**NON MATERIAL AMENDMENT TO THE PROPOSED SITE LAYOUT APPROVED UNDER
PLANNING PERMISSION 3/2020/0332
LAND OFF SHEEPFOLD CRESCENT, BARROW, BB7 9XR**

I am pleased to submit an application under Section 96a of the Town and Country Planning Act 1990 for a non-material amendment following the approval of reserved matters (ref. 3/2020/0332) at land off Sheepfold Crescent, Barrow on behalf of our client Oakmere Homes.

<b>DRAWN BY</b>	RL	<b>REV</b>	A
<b>ADDRESS</b>			
Sheepfold Crescent, Barrow Brook			
<b>PROJECT TITLE</b>			
Residential Development			
<b>DRAWING TITLE</b>			
Finished Floor Level Plan			
<b>DRAWING NUMBER</b>			
LH/SCB/FFL/01			
<b>DATE</b>	<b>SCALE</b>		
20/04/20	1:500 @ A2

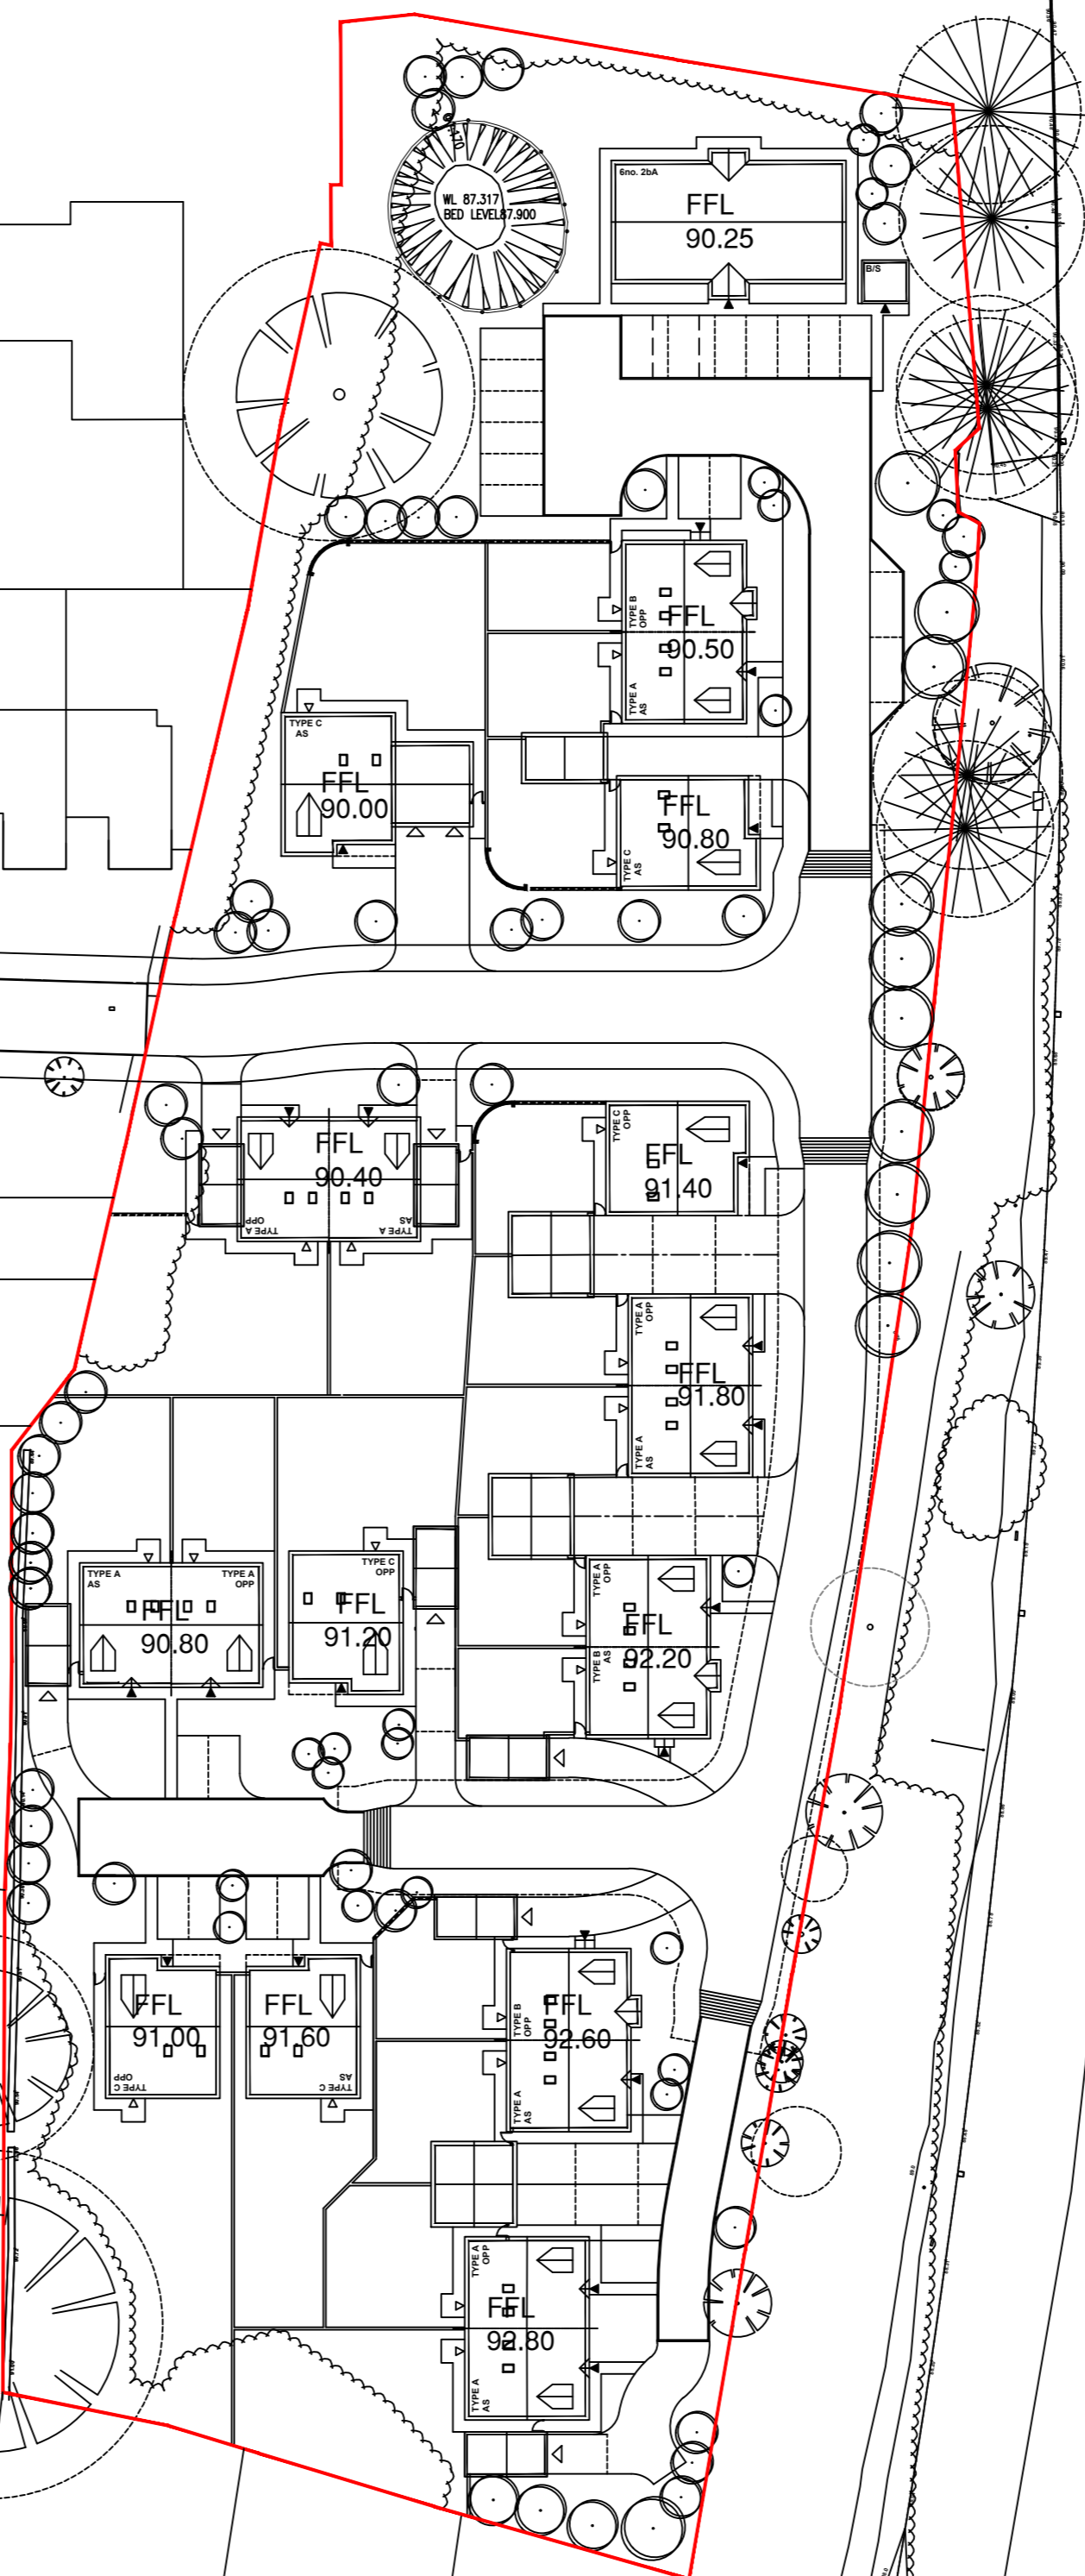
This application seeks to amend the proposed site layout to allow most of the plots to have a garage, while making minor adjustments to the location of approved garages and landscaping verges / fences. See the exact changes explained below:

- Introduction of single garage at plots 2, 11, 12, 13, 14, 15, 16, 17, 18, 20, 23, 24, 15 and 26.
- Relocation and introduction of double garage at plot 1.
- Landscaping and parking amendments to the front of plots 19, 20, 23 and 26.
- Fencing amendments between plots 22, 24 and 25.
- Swop of orientation of house at plots 2 and 13.
